Ribble Valley Borough Council

DELEGATED ITEM FILE REPORT - REFUSAL

Application No:	3/2013/1060
Development Proposed:	Construction of a part two storey, part single storey side extension for residential accommodation at 70a Downham Road, Chatburn.

Proposed Front Elevation - 1:100

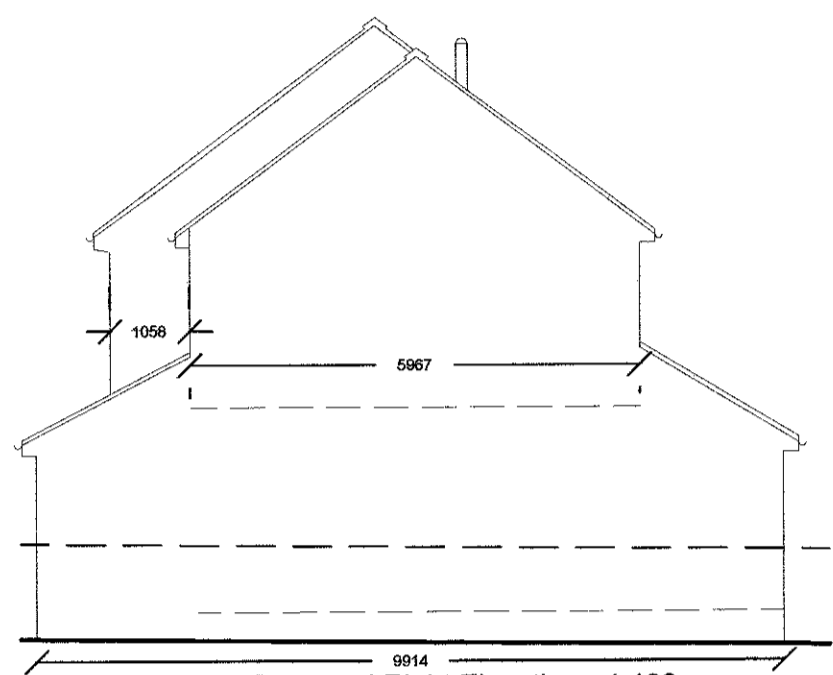
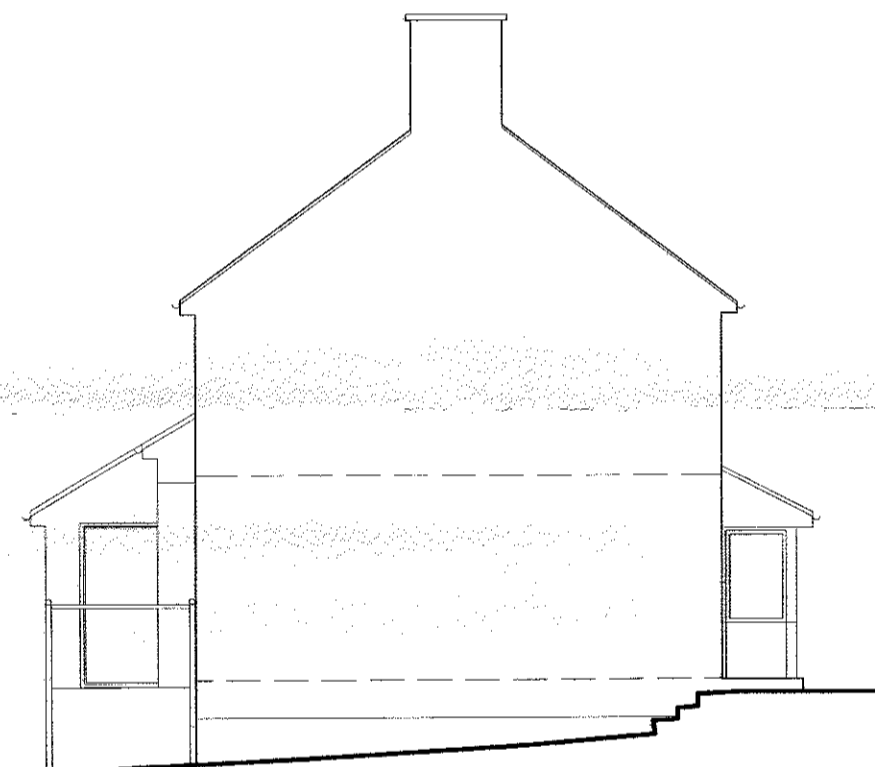
The proposed development is to measure 4.8m x 9.9m at ground floor level whilst at first floor level the extension will measure 4.8m x 6.4m. The extension is to be constructed to an eaves height of approximately 5m and built to an overall ridge height of 7.6m. The development will be constructed from rendered elevations under dual pitch slated roofs. At ground floor there will be monopitched roofs used at the front and rear which will act to bridge the variation in the dimensions between the ground and first floors. The monopitched roof to the front will continue across the front of the dwelling to incorporate an overhanging porch detail.

Since the original submission was made the plans have been amended to address concerns that had been raised. These amendments included the removal of proposed bi-folding doors and rooflights to the front elevation of the proposed extension at ground floor. These were considered to be alien features that would appear incongruous on a principle elevation, increasing the prominence of the development. The overall projected width of the extension has also been reduced from 5.9m to 4.8m. This was to address concerns that the proposed side extension would appear over dominant when set against the original dwelling. It is considered that the proposal as now amended is more keeping with the existing dwelling and visually is better proportioned.

The proposed first floor element of the proposed extension would be set back from the principle elevation of the existing dwelling by 500mm and the ridge set down from that of the existing dwelling by 400mm. The inclusion of such features ensures that the proposed development does appear as a later subservient addition rather than an original feature.

The proposed development will result in an increase in the overall height of built form by virtue of the introduction of a first floor. This will have an impact upon the neighbouring property of No.72 Downham Road resulting in a loss of natural light to a window in the opposing side elevation of No.72. From visiting the neighbouring property this window in question serves the kitchen area of the property, which is also used as a kitchen diner. I did note however during my visit that the side elevation window did allow for natural light to fall into the kitchen diner space owing to its orientation to the west. In addition to which there is a further window opening on the rear of the elevation of No.72 that serves the same room.

Therefore in the context of this application, when assessed against the provisions of the adopted SPG the kitchen of No.72, by virtue of being a kitchen diner would be considered to be a habitable room. I therefore consider that the proposed development would by virtue of its scale, design, mass and proximity to the neighbouring property would result in overshadowing and the loss of natural light to a habitable room, this would be contrary to the provisions of the adopted SPG and be harmful to the residential amenity of the occupants of No.72. This impact would principally be caused by the provision of a first floor on the proposed development and the resulting increase in height. The actual separation distance between the two properties would remain broadly the same at approximately 8.5m.

However as discussed above, the proposed development would result in the loss of natural light and result in the overshadowing of a habitable room of a neighbouring property. This would be prejudicial to the residential amenity of the occupants of this dwelling to an extent that I feel would warrant the refusal of consent on such grounds. I therefore recommend accordingly.
